Application No: BN/150/20/PL
Site Address: Land at Chantry Mead & Rear of 14 -18 Downview Road Barnham PO22 0EG
Description of works: 3 No dwellings including access, landscaping & associated works (resubmission following BN/51/20/PL). This site is in CIL Zone 2 and is CIL Liable as new dwellings.

Thank you for your internet representation made on 13th March 2021 which has been recorded as an objection with the comments as follows:

PLOT 3 ELEVATIONS
SCALE 1:100 @ a3

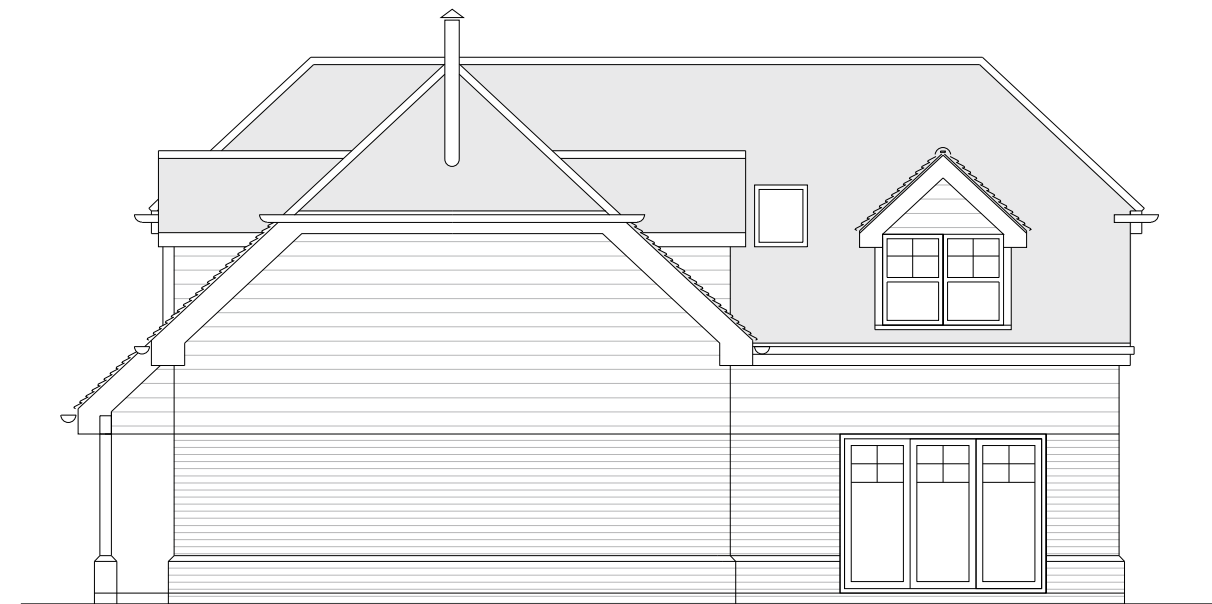
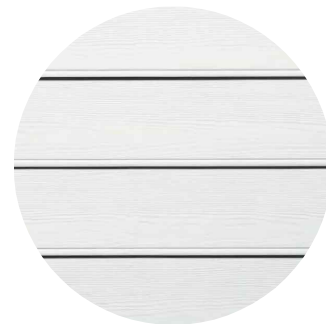
We object to this application with regard to the proposed look of plot number 3: the roof is shown to be of black/dark grey slate which is out of keeping with the surrounding houses roofs that we can see from our house. All existing Chantry Mead houses have red tile roofs as is proposed for plot 1 and 2. The finish of the house at plot 3 should be similarly coloured so as to match its surroundings.
